Application No: R/222/21/HH
Site Address: 42 Pigeonhouse Lane Rustington BN16 2BE
Description of works: Single storey rear extension and hip to gable loft conversion with 2 x dormers following the demolition of existing rear conservatory

Thank you for your internet representation made on 20th October 2021 which has been recorded as an objection with the comments as follows:

A 04

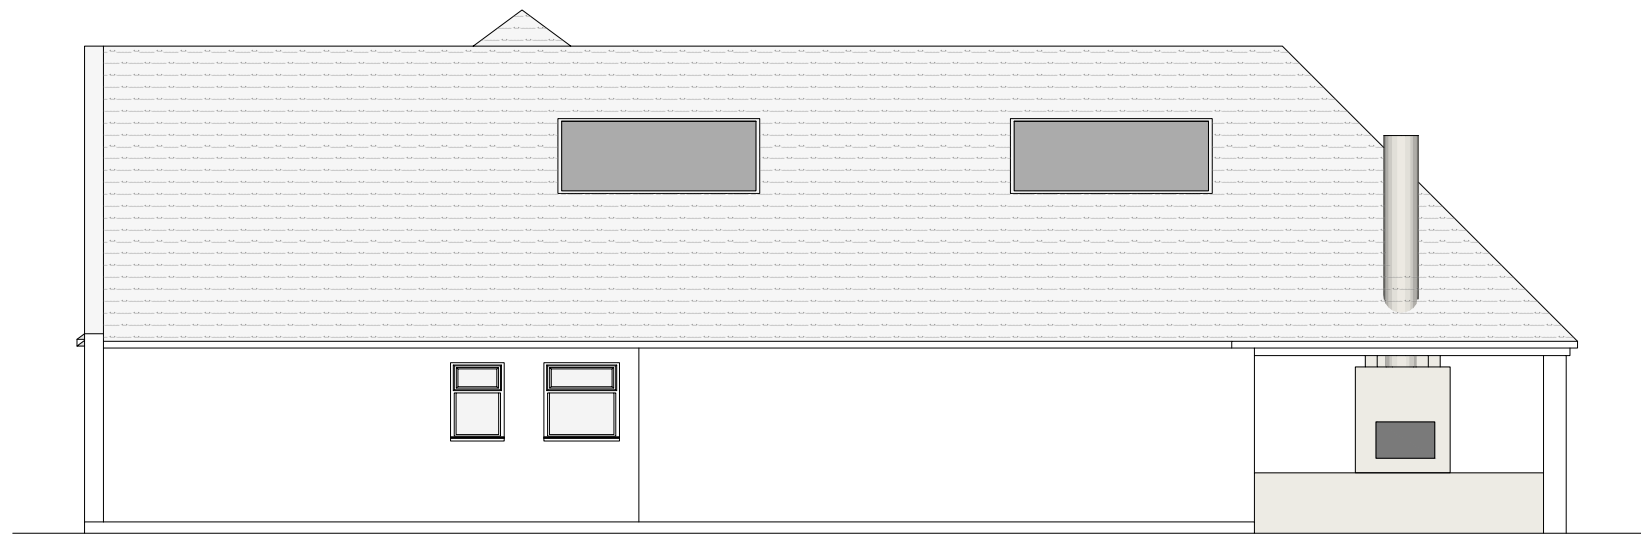
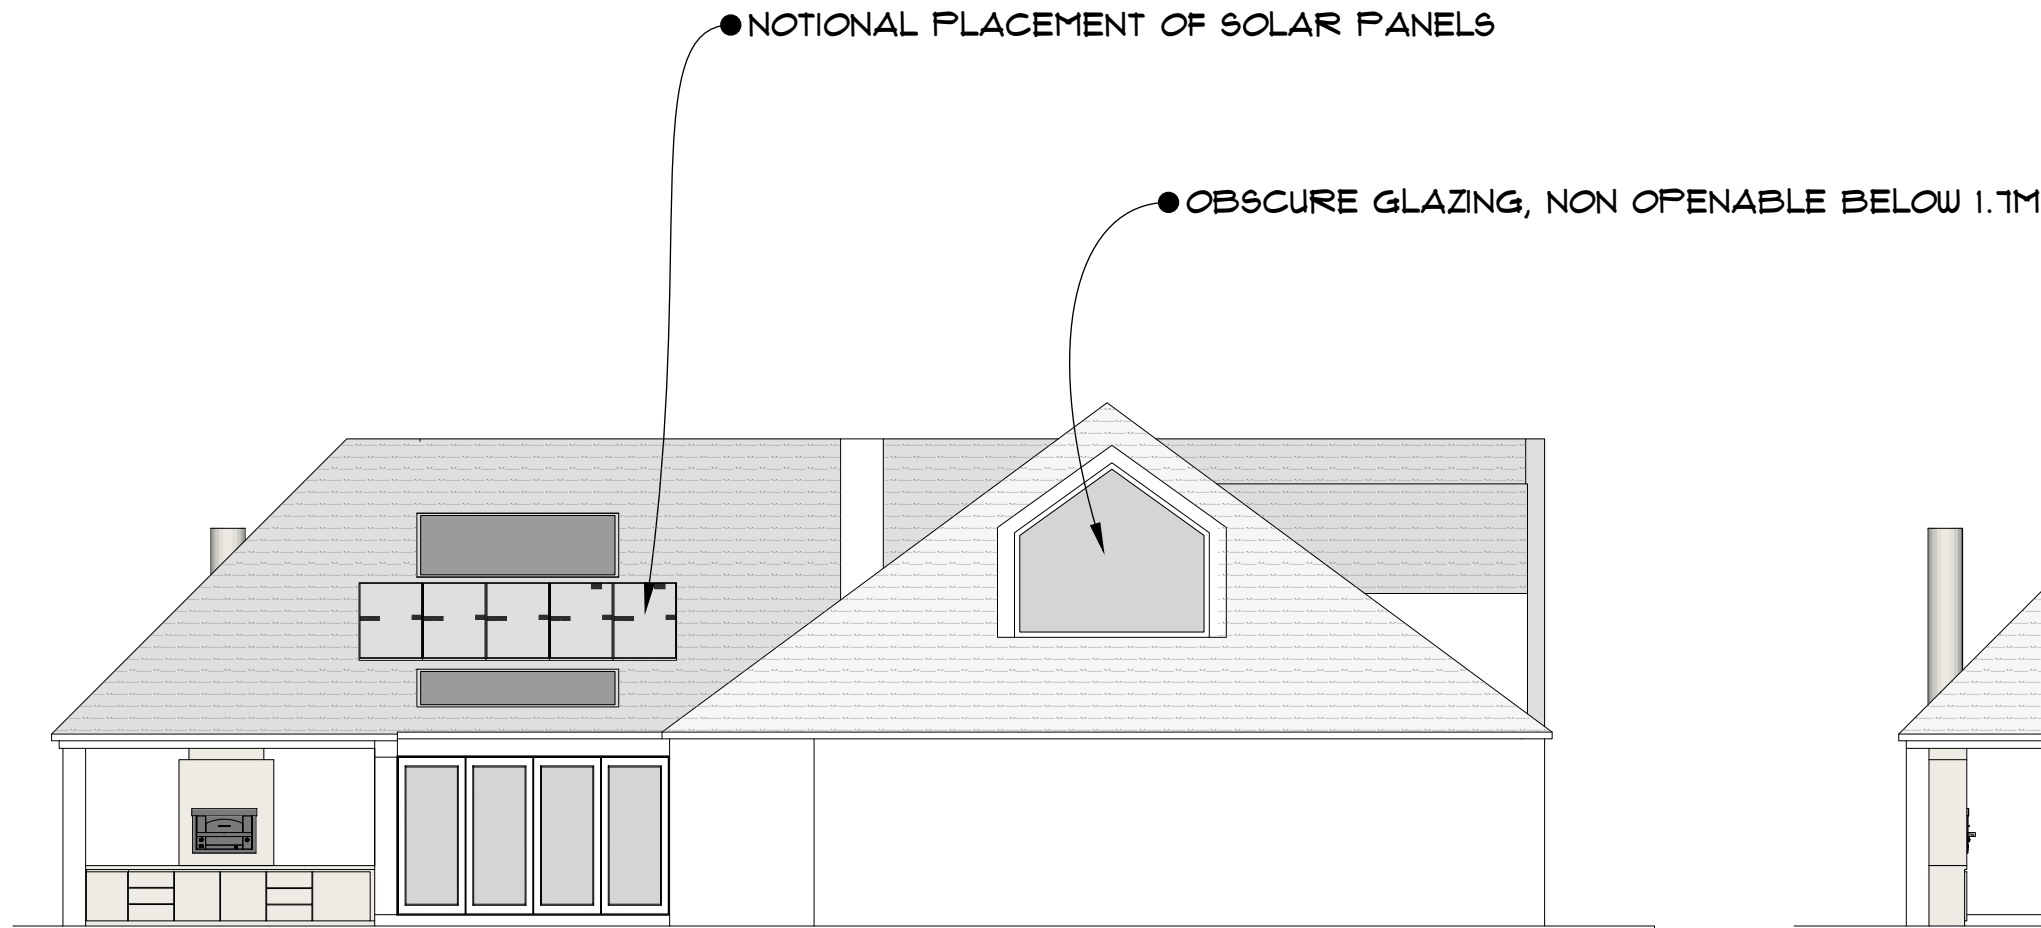
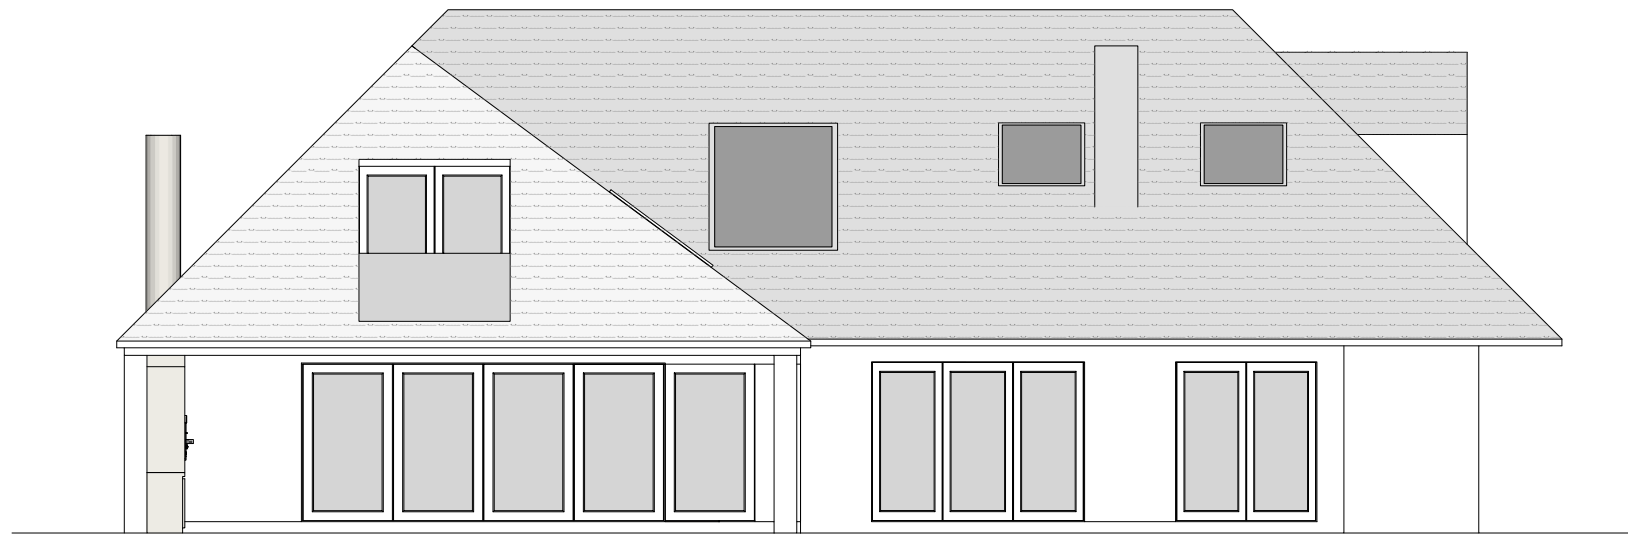
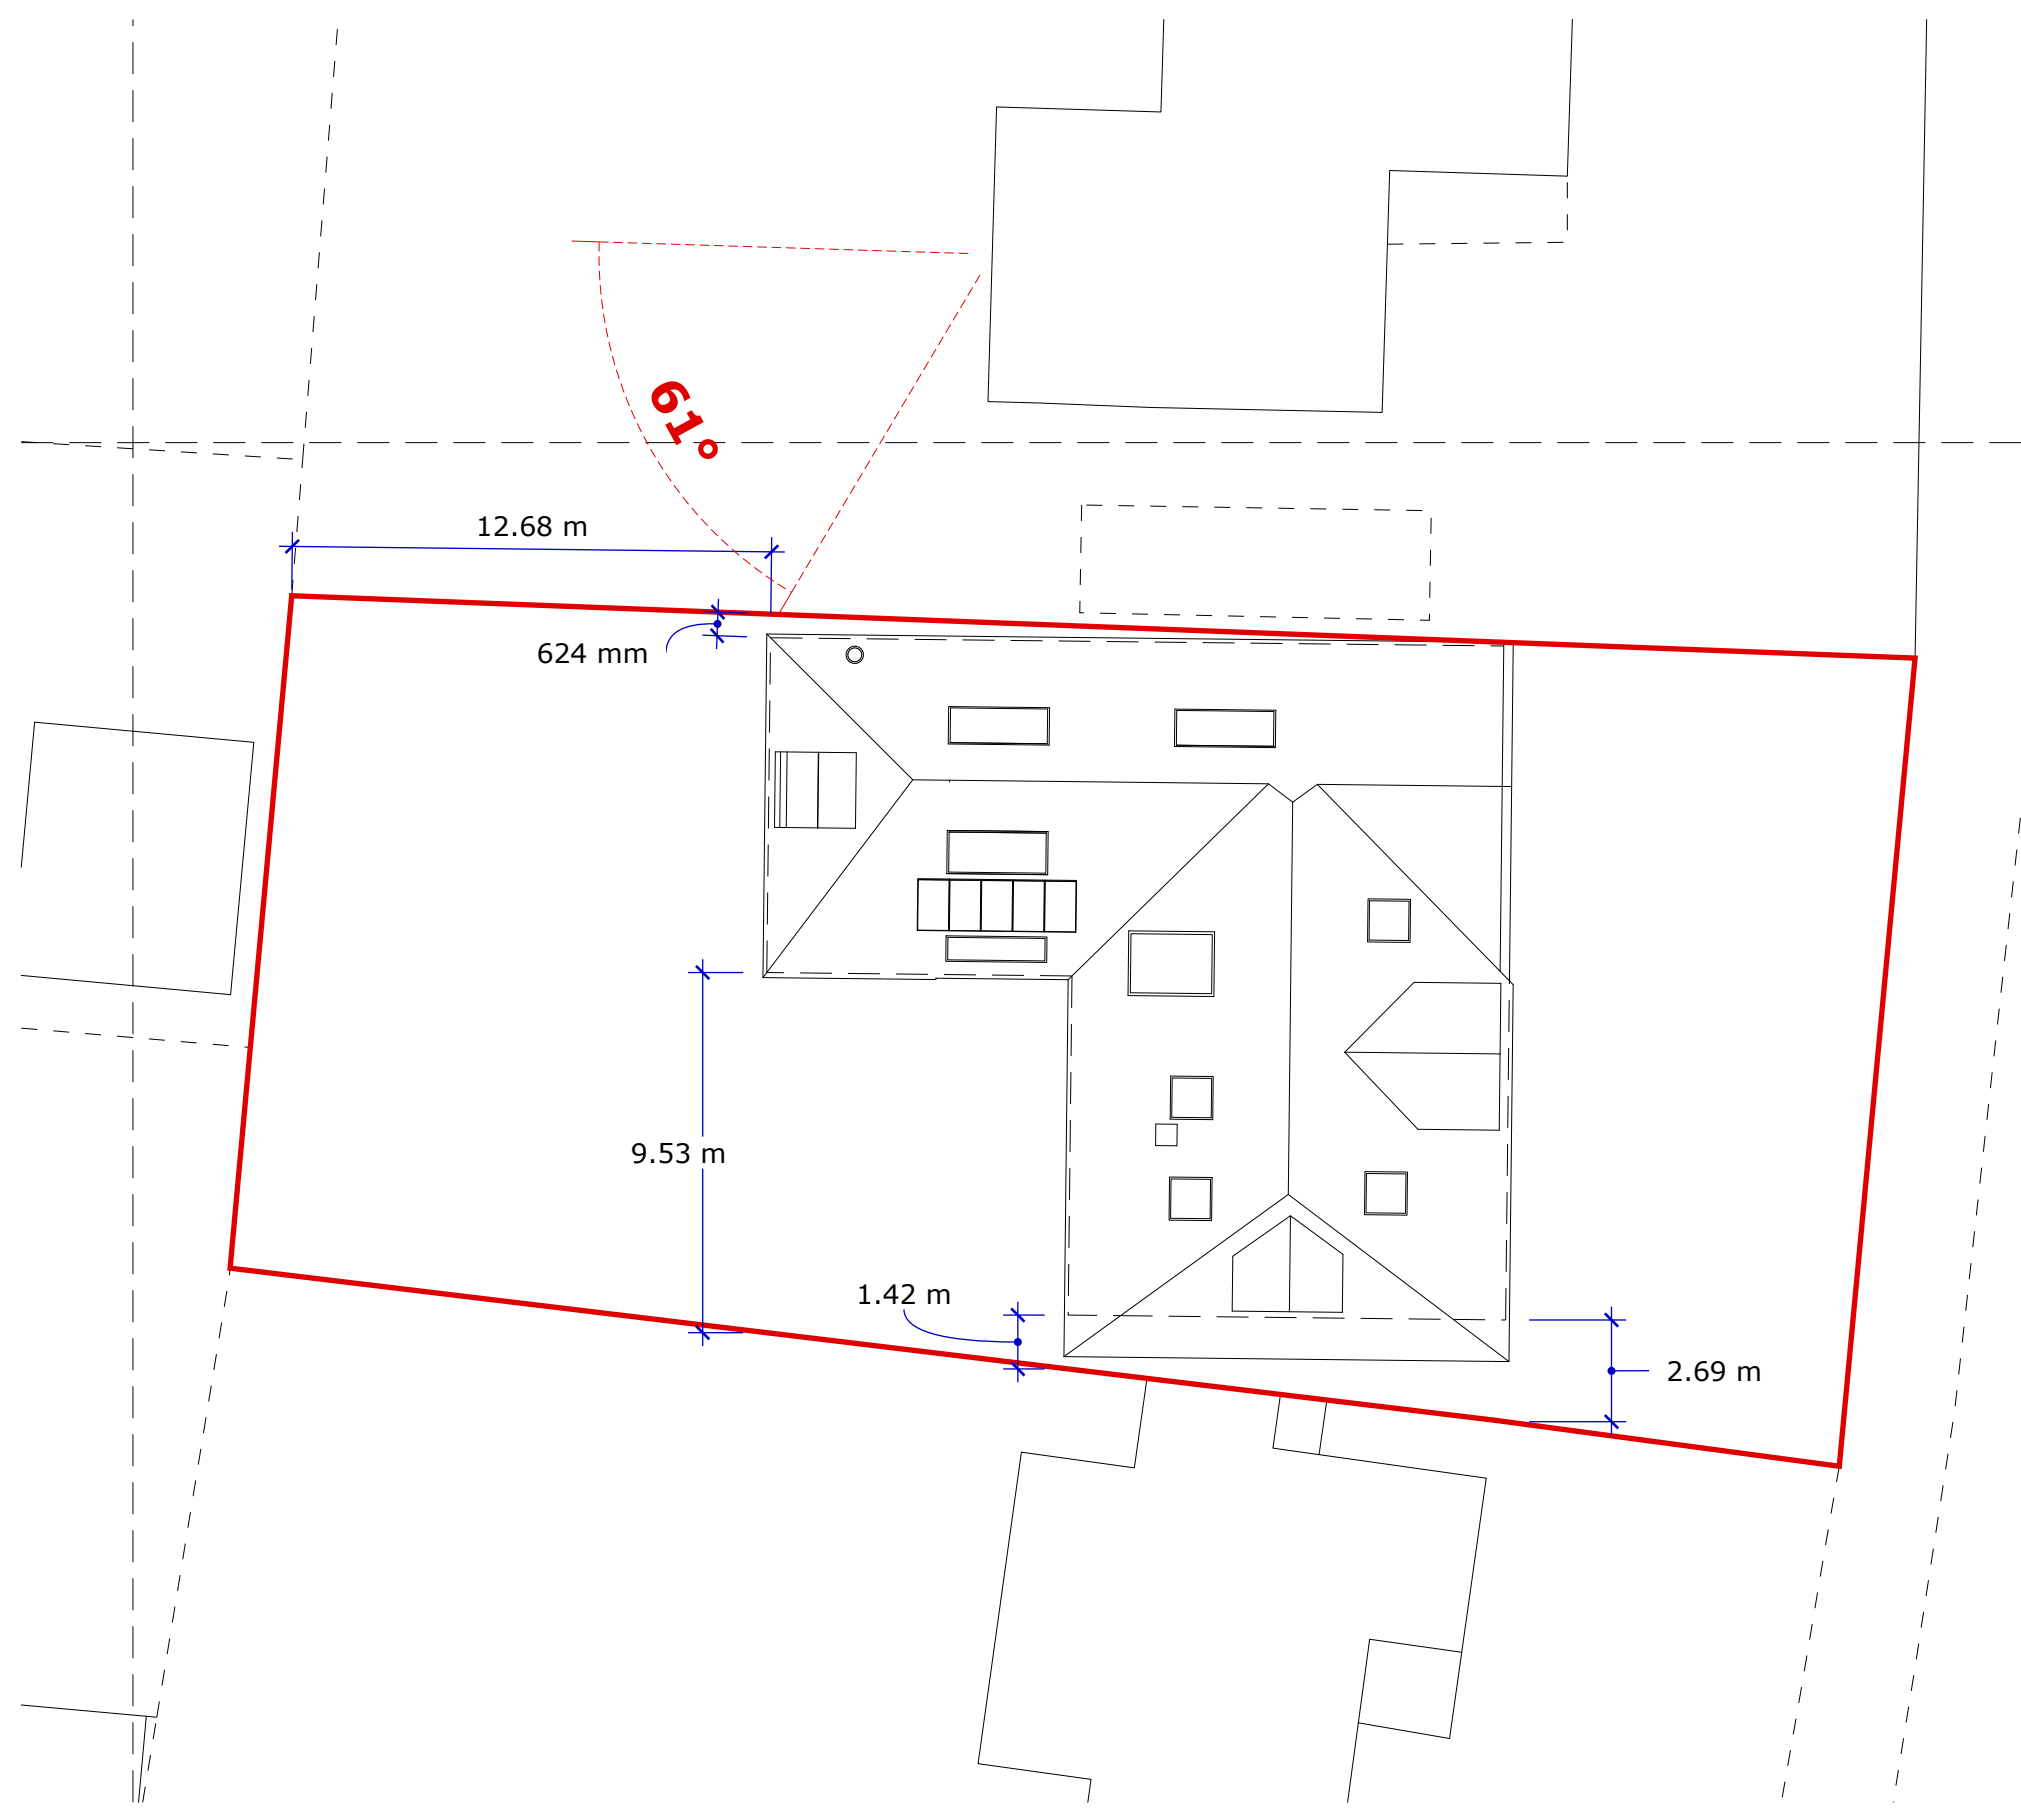
2. The proposed extension to the rear would extend along a considerable part of our shared boundary (our southern boundary, the applicant's north). The proposed extension includes windows which would overlook our bungalow and garden. The addition of a balcony, will result in both our bungalow and our primary seating area in our garden being overlooked resulting in a serious invasion of our privacy. We feel the proposed extension does not afford adequate privacy for us and also with regard to our right to the quiet enjoyment of our garden amenities. We would urge you to consider the responsibilities of the council under the Human Rights Act in particular Protocol 1, Article 1 which states that a person has the right to peaceful enjoyment of all their possessions which includes the home and other land. We believe that the proposed works would have a dominating impact on us and our right to the quiet enjoyment of our property. Article 8 of the Human Rights Act states that a person has the substantive right to respect for their private and family life.

3. The proposed extension will cause considerable overshadowing to our bungalow and garden and block a significant amount of light to our property. A large part of our garden, which runs along the proposed building line (our southern boundary the applicant's north), will see limited natural light and particularly so during the winter months when the proposed extension will block any winter sun.

4. We strongly object to the chimney which will again be situate on the boundary line (our southern, the applicant's north). Any smoke from the chimney will blow directly onto our property by virtue of the frequent south westerly winds we experience at the property and generally in this area. The smoke will have a considerable negative impact on our air quality. The smoke is also likely to cause considerable grime in our property and will affect when and how often we can open our windows and patio doors for 'fresh air'. We feel the chimney is in any event at complete odds with both the Council and the Government's proposals and polices to reduce energy consumption and emissions and the use of greener options.

Sheet:
A 05

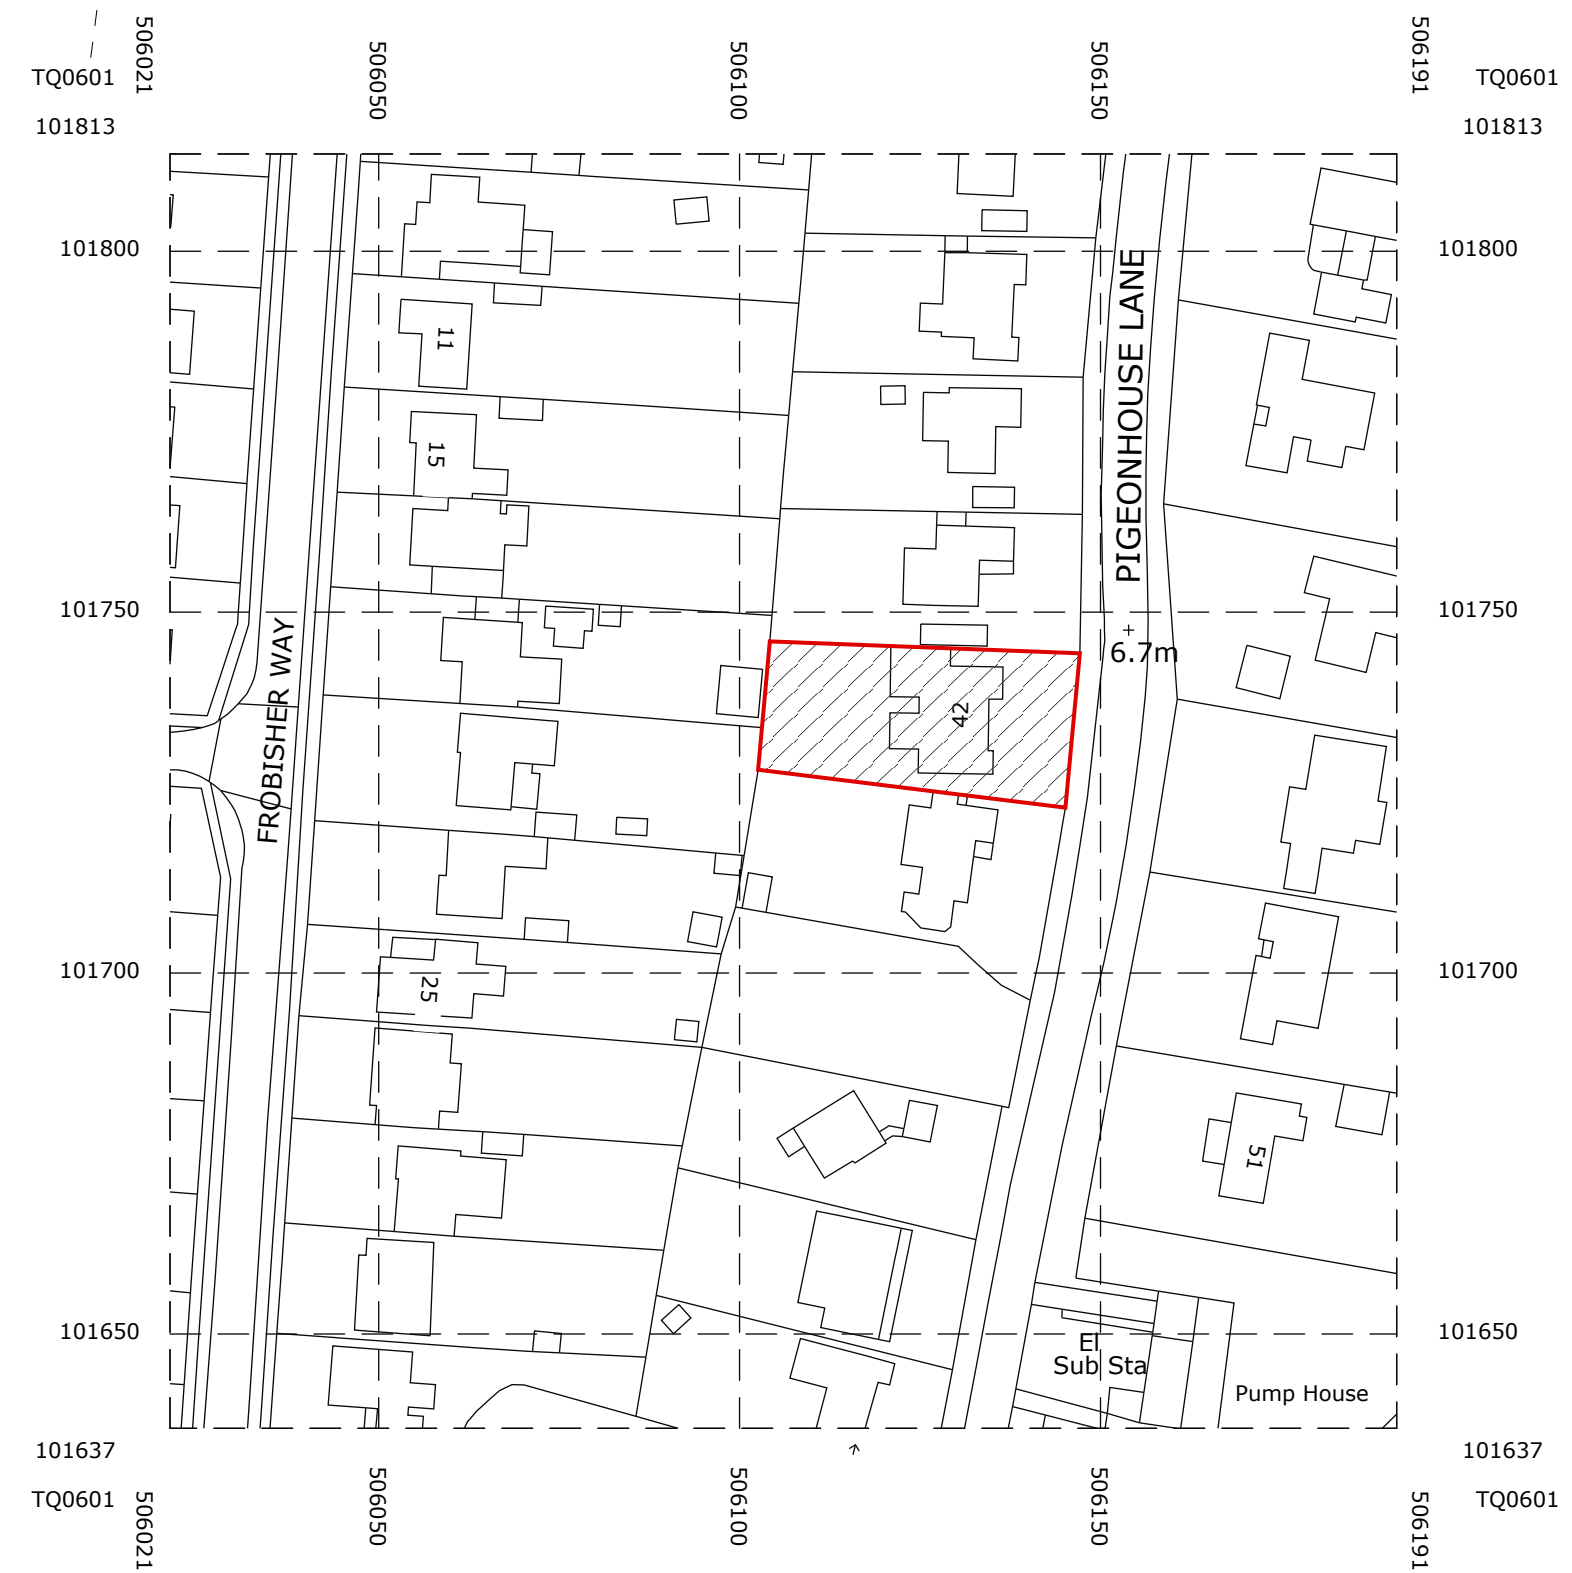
1. Our property, 40 Pigeonhouse Lane, Rustington, can be seen to the north of the applicant's plan on sheet A05. The red line on the plan is on our boundary and you can clearly see our garage is shown directly to the north of the boundary line.
